Planning Inspectorate

Our Ref: EN0110012

Date: 20 April 2026

Application by Light Valley Solar Limited for an order granting development consent for the Light Valley Solar project

Key

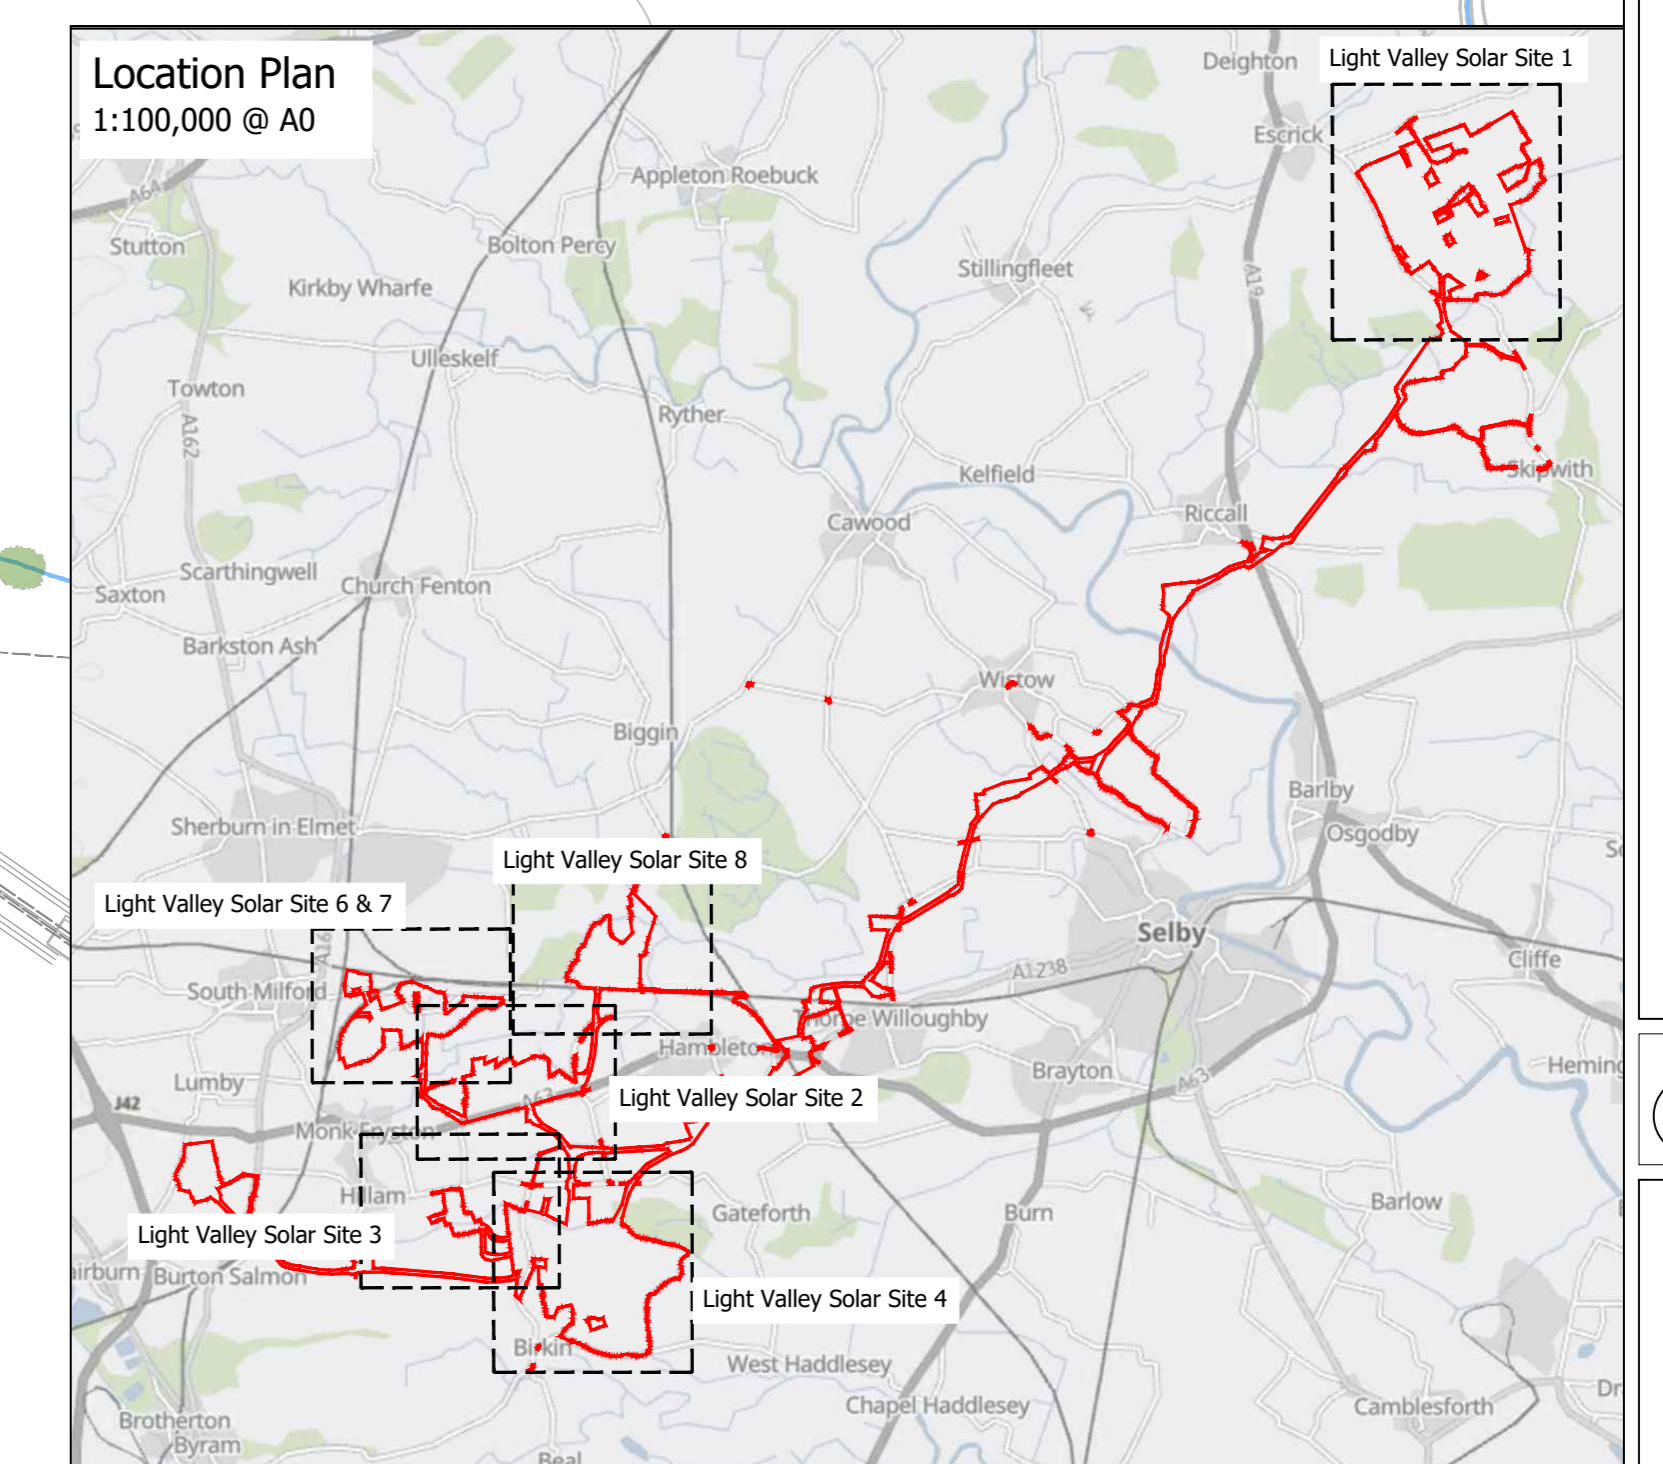
- 02.12.01 to 02.12.08 Outline Environmental Masterplans Site 1 to 8 due to continued lag and latency issues and lengthy file opening times experienced by the

Planning Inspectorate. These would be likely encountered by interested parties, affected persons, the ExA and others during the examination stage.

- **02.12 Outline Environmental Masterplan [APP-016]**– amended file/s of a standard that will enable multiple documents to be opened on a computer in good time and effectively used concurrently.

Figure 15.10

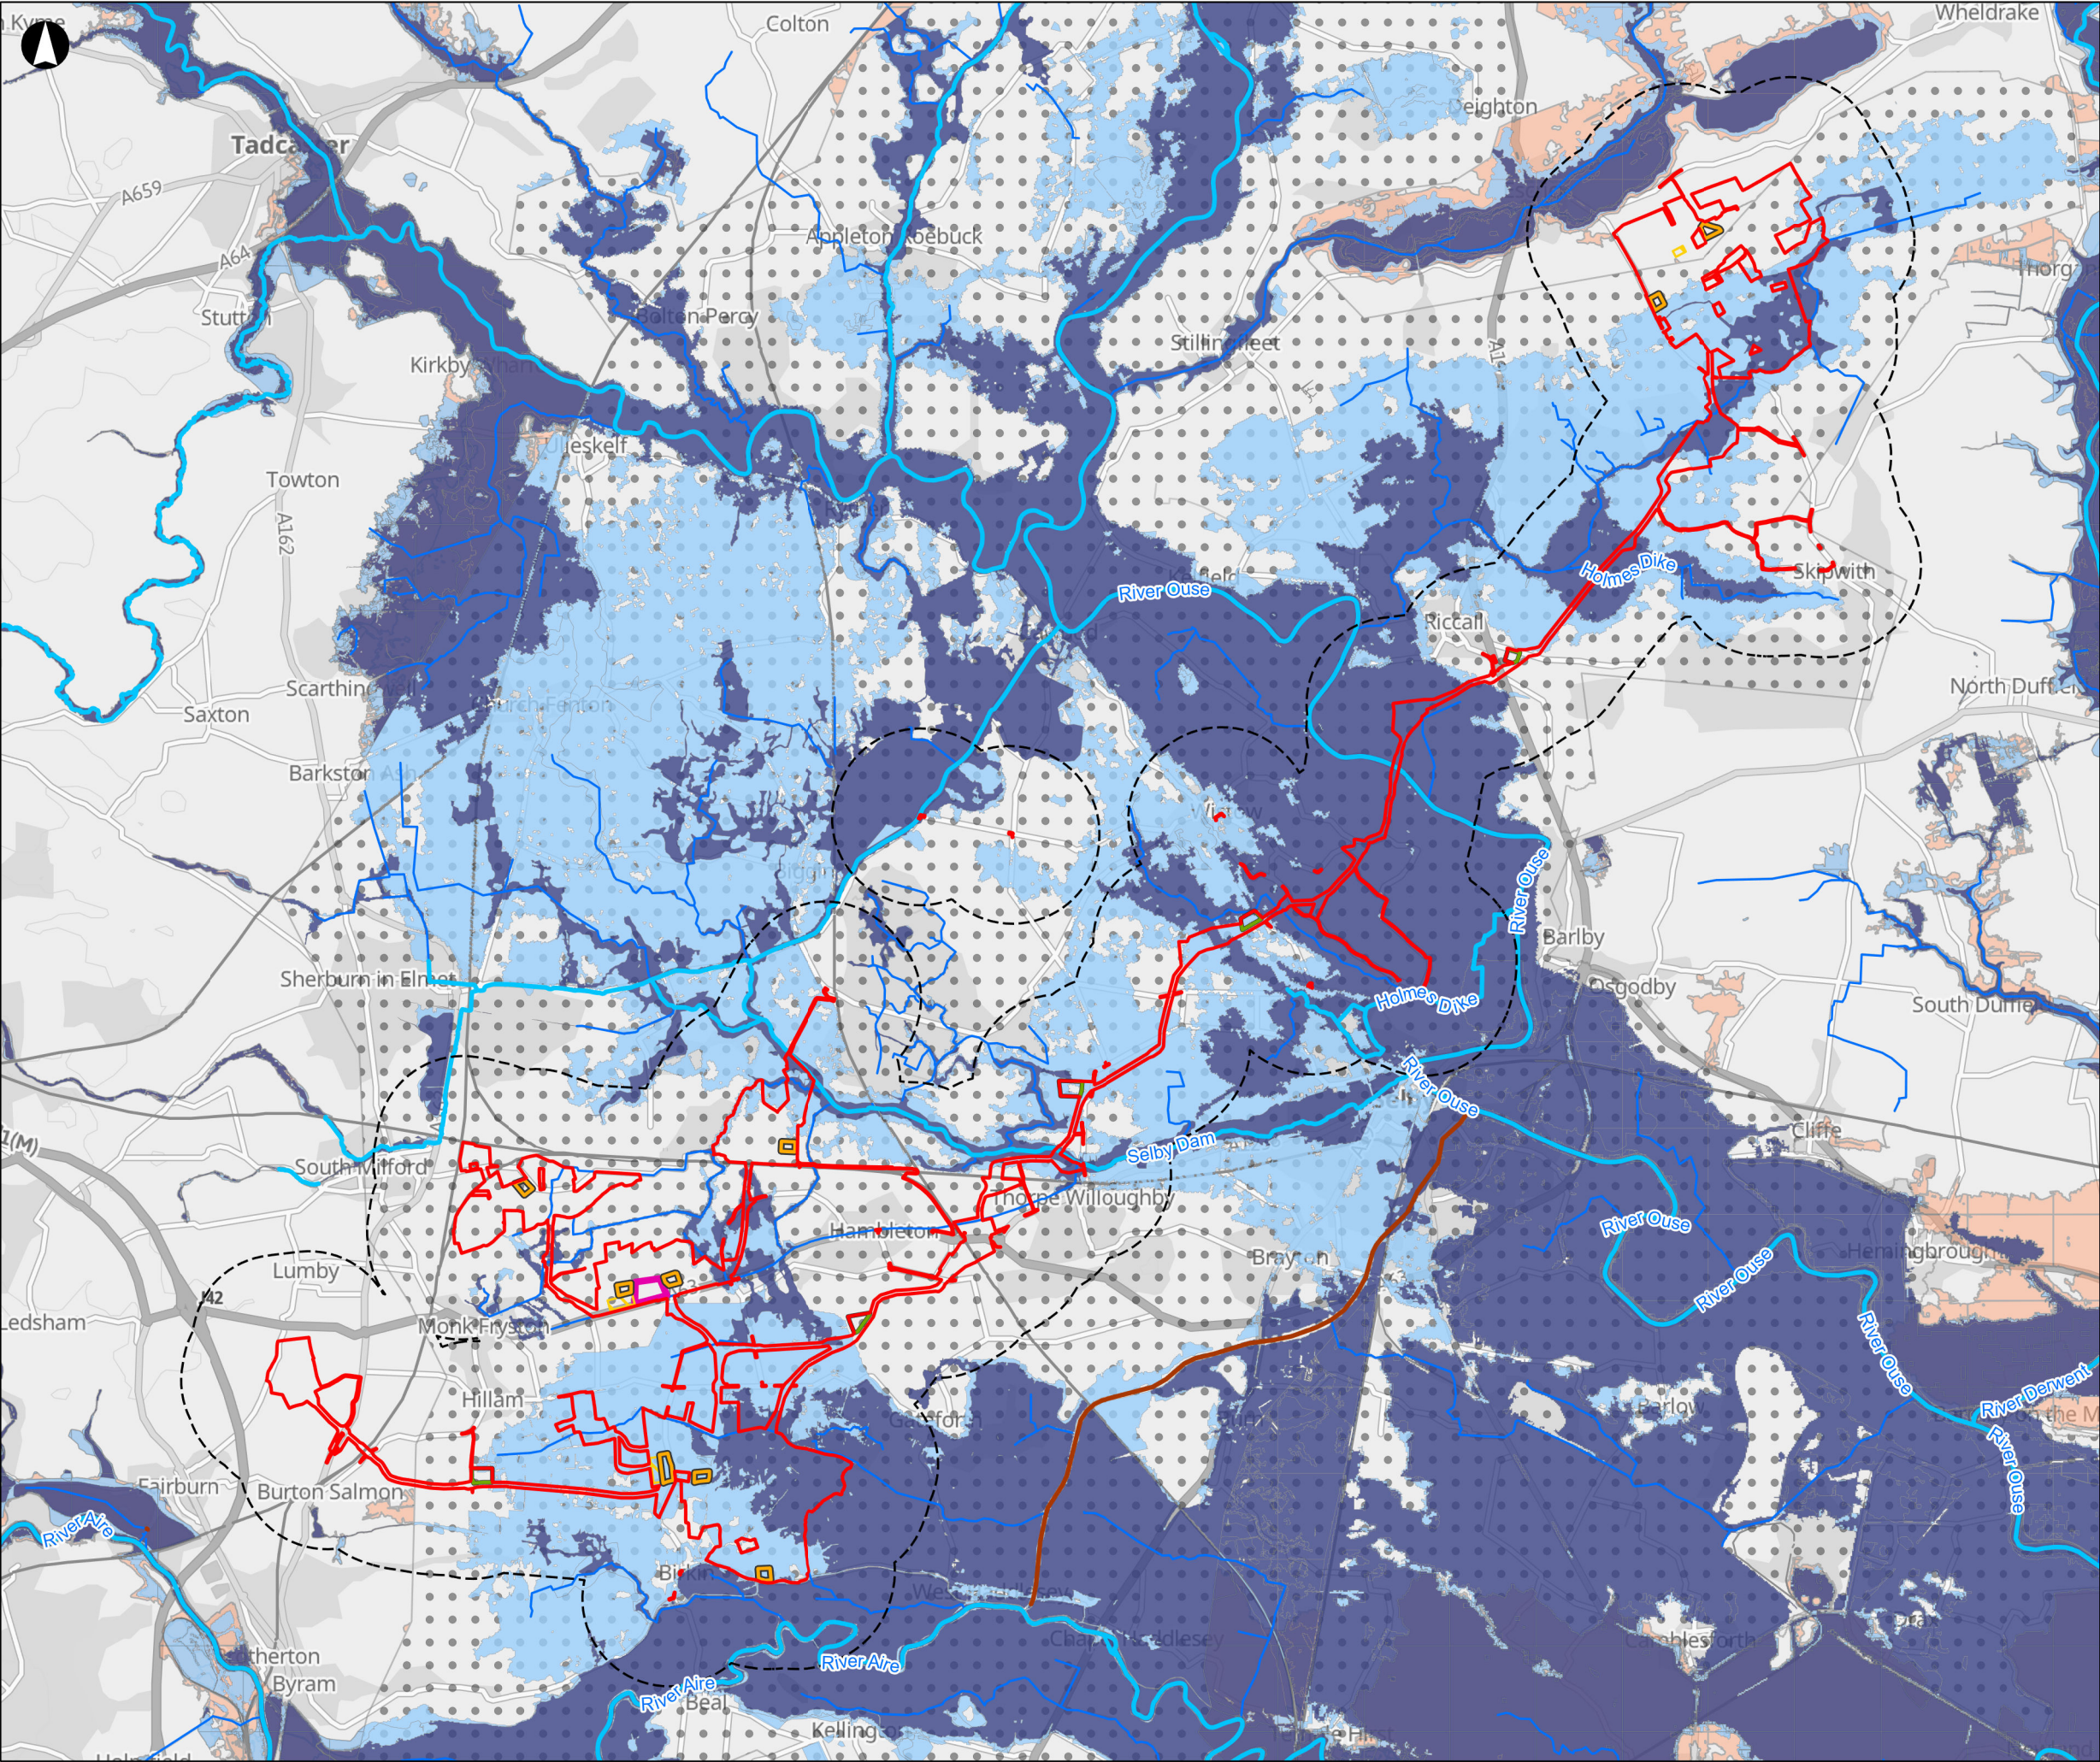
- **06.03.15.01 Environmental Statement Volume 3 Appendix 15.1 Flood Risk Assessment [APP-179]** – amended figures that identify the current and future Flood Zones 2, 3a and 3b in context of the proposed development and study area.
